**WELWYN HATFIELD BOROUGH COUNCIL  
EXECUTIVE DIRECTOR - PLANNING, PUBLIC PROTECTION AND GOVERNANCE**

**Application No:** 6/2021/2873/HOUSE  
**Location:** 71 Pine Grove Brookmans Park Hatfield AL9 7BL  
**Proposal:** Alterations to front boundary to create new masonry wall and railings with electric gates  
**Officer:** Ms Kirsty Shirley

**Recommendation:** Refused

Proposed Front Elevation

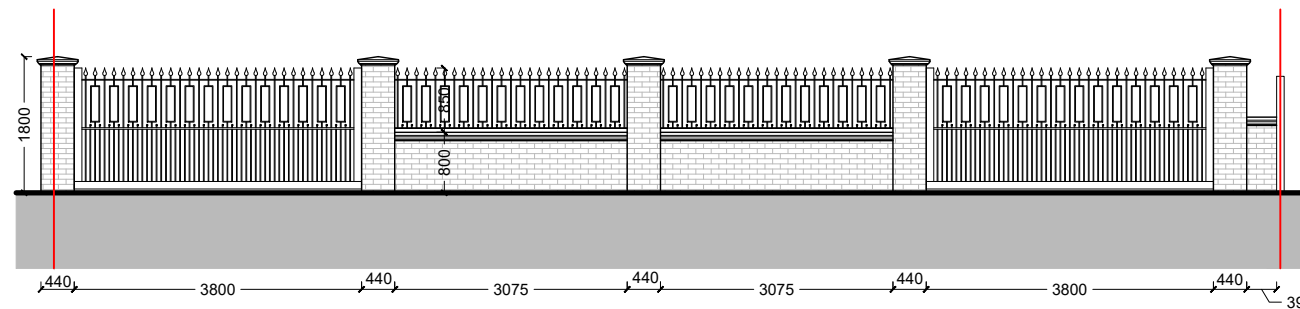
The proposed boundary treatment is for the erection of brick walls, brick pillars and metal railings. The brick walls would be approximately 0.8m in height, with brick pillars positioned every 3.8m. The brick pillars measure approximately 1.8m in height. Metal railings would be situated on top of brick walls between the brick pillars, and would measure approximately 1.65m in height. Two sliding gates would be inserted into the front boundary treatment, which would also be railings in the same style as the railings atop of the brick walls. The gates would measure approximately 1.65m in height. The gates would be set back from the road by approximately 3.8m. This boundary treatment would be located to the front of the site only.

The proposed front boundary treatment would be much higher when compared to other boundary features within the context of the application site. It is noted that taller boundary treatments exist between property boundary lines, however front boundary treatments within this area are predominantly low brick walls, soft landscaping or left open. Consequently, the height and scale of the proposed boundary treatment would be a prominent and uncharacteristic feature which would intrude into the street scene.

**DRAWING TITLE :**  
 Proposed Front Garden Plan

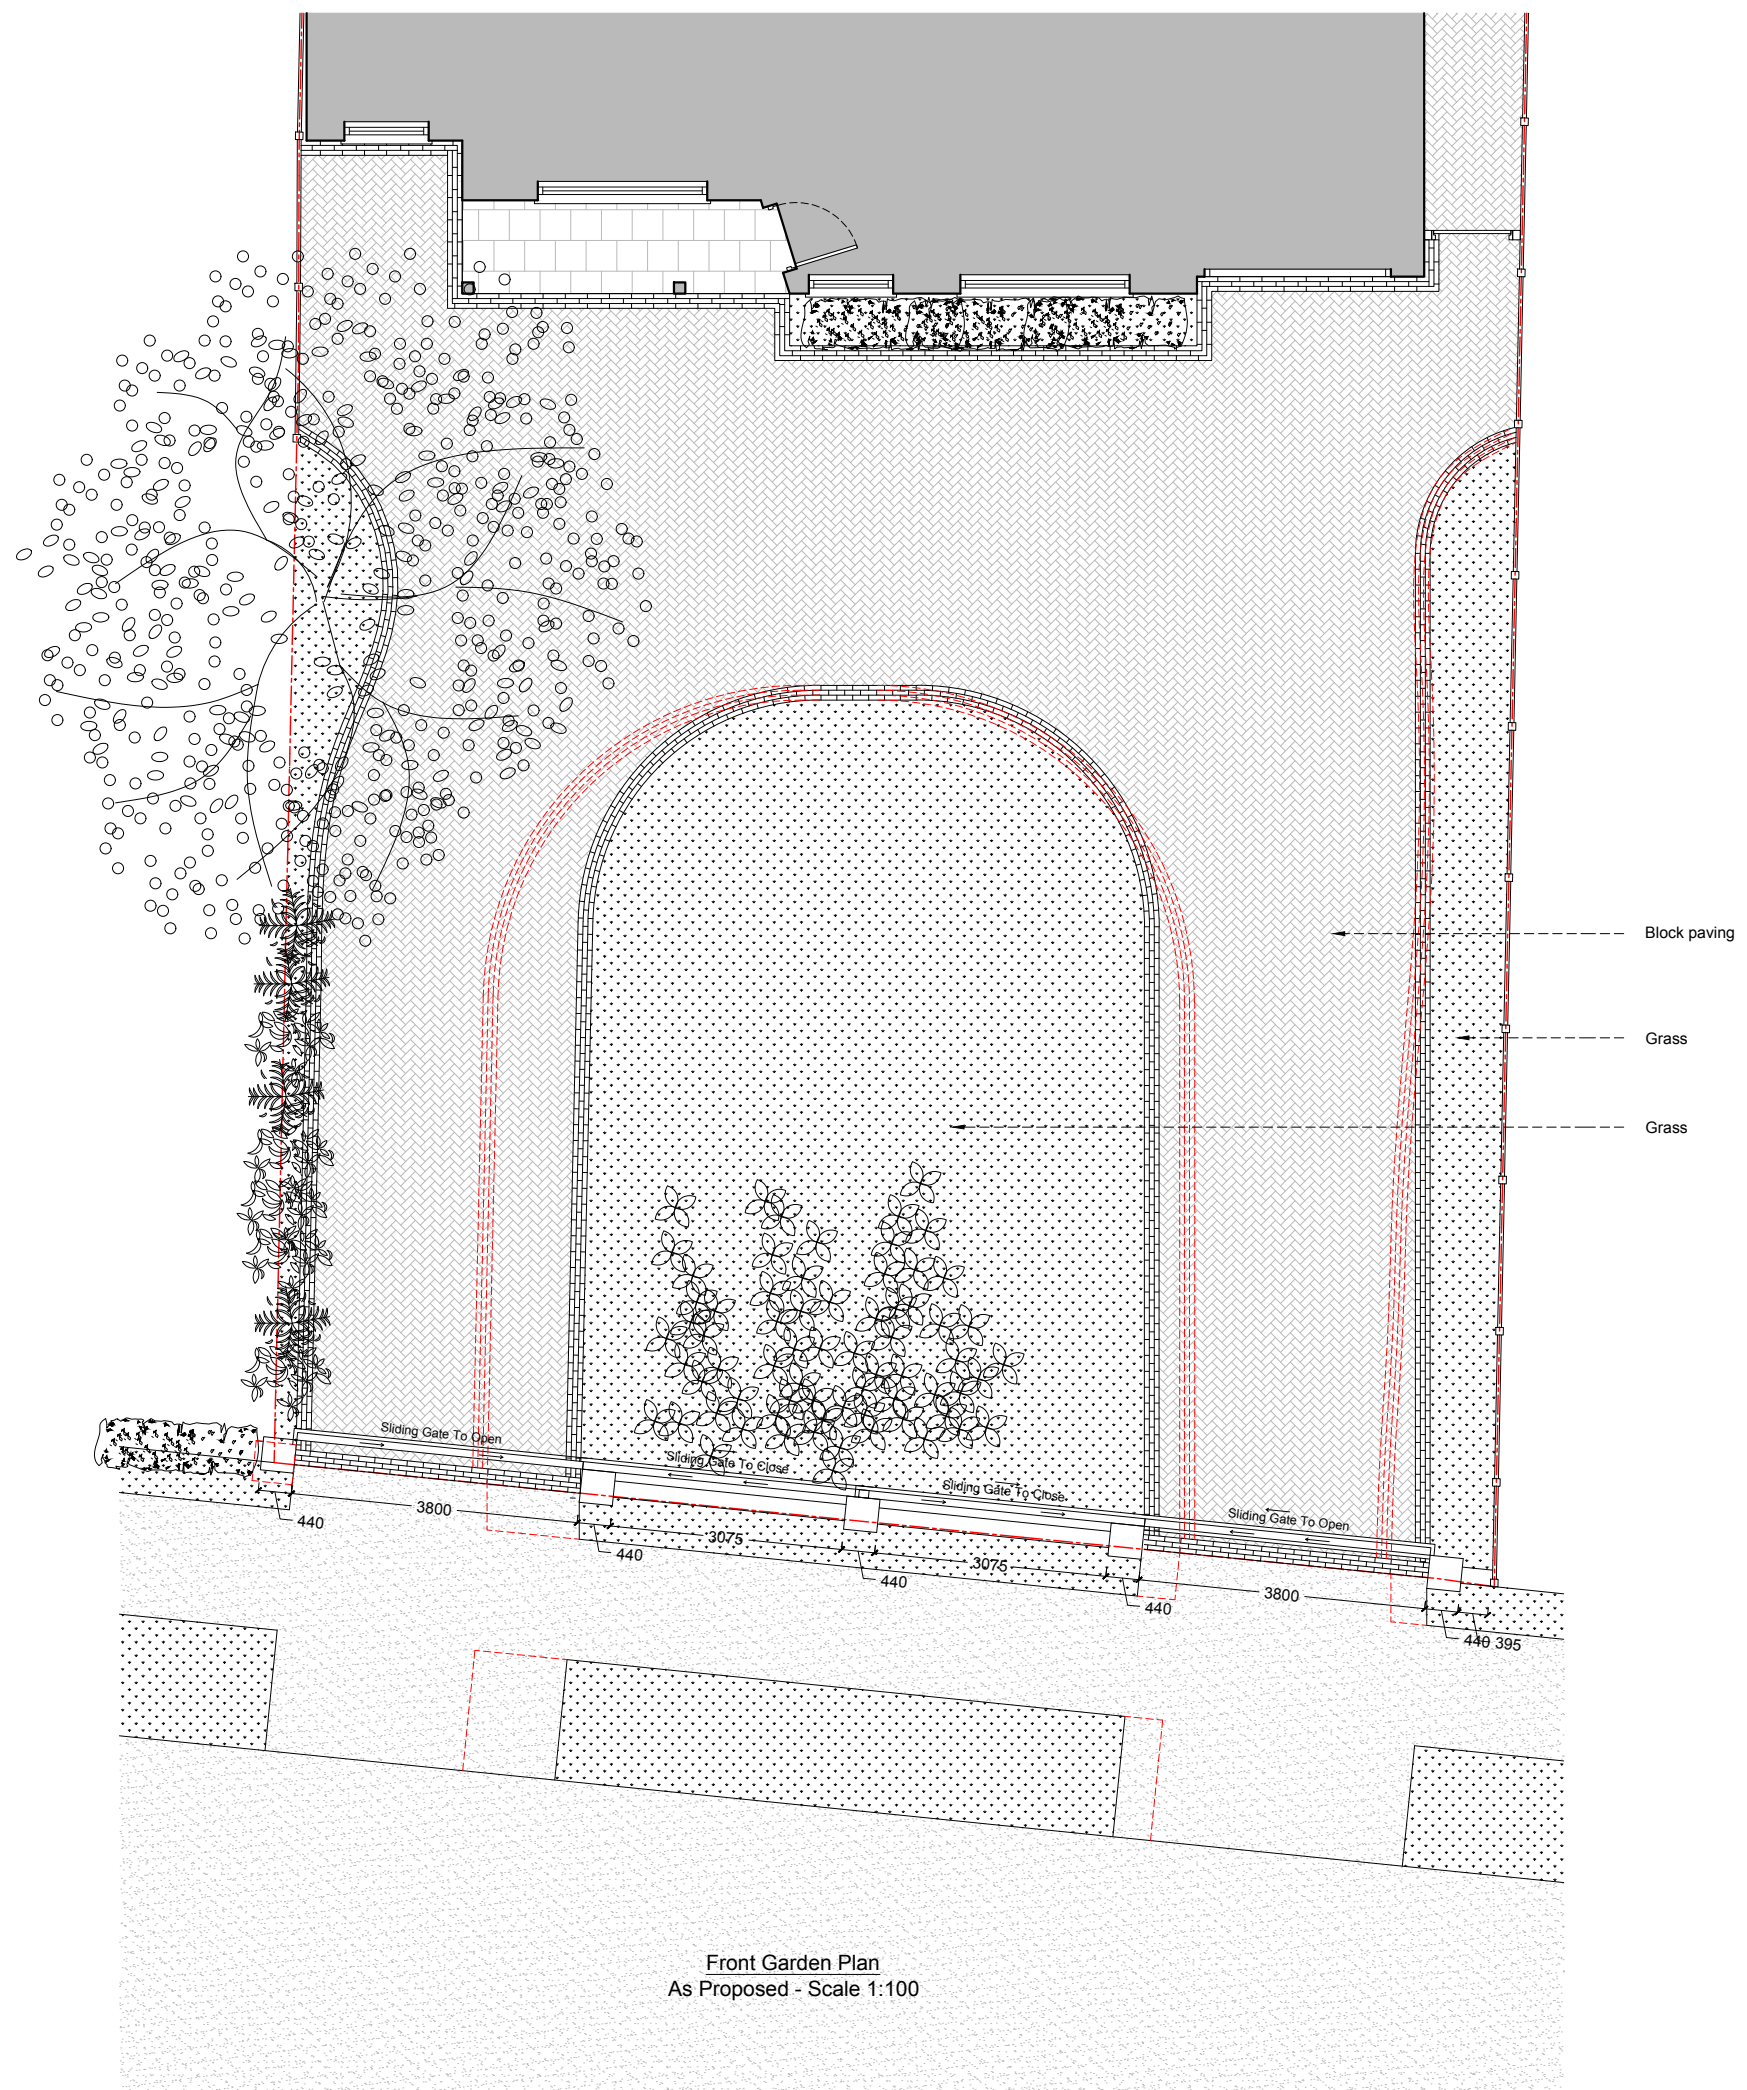
<p><b>Conclusion</b></p>	
<p>The proposed development by virtue of its siting, height, and design, would result in an incongruous and unduly dominant addition to the street scene which would fail to respect the character and appearance of the spacious and open character of the area. As such, the proposal would be harmful to the visual amenity of the street scene and contrary to District Plan Policies D1 and D2; the Supplementary Design Guidance; and the National Planning Policy Framework.</p> <p>Furthermore, the proposal would have an adverse impact on the safety and operation of the adjoining highway network contrary with the relevant policies of the Welwyn Hatfield District Plan and the National Planning Policy Framework.</p>

1. The proposed development by virtue of its siting, height, and design, would result in an incongruous and unduly dominant addition to the street scene which would fail to respect the character and appearance of area. Accordingly, the proposed development represents a poor standard of design and is therefore contrary to District Plan Policies D1 and D2; the Supplementary Design Guidance; and the National Planning Policy Framework.
2. The proposal would have an adverse impact on the safety and operation of the adjoining highway network contrary with the relevant policies of the Welwyn Hatfield District Plan and the National Planning Policy Framework.
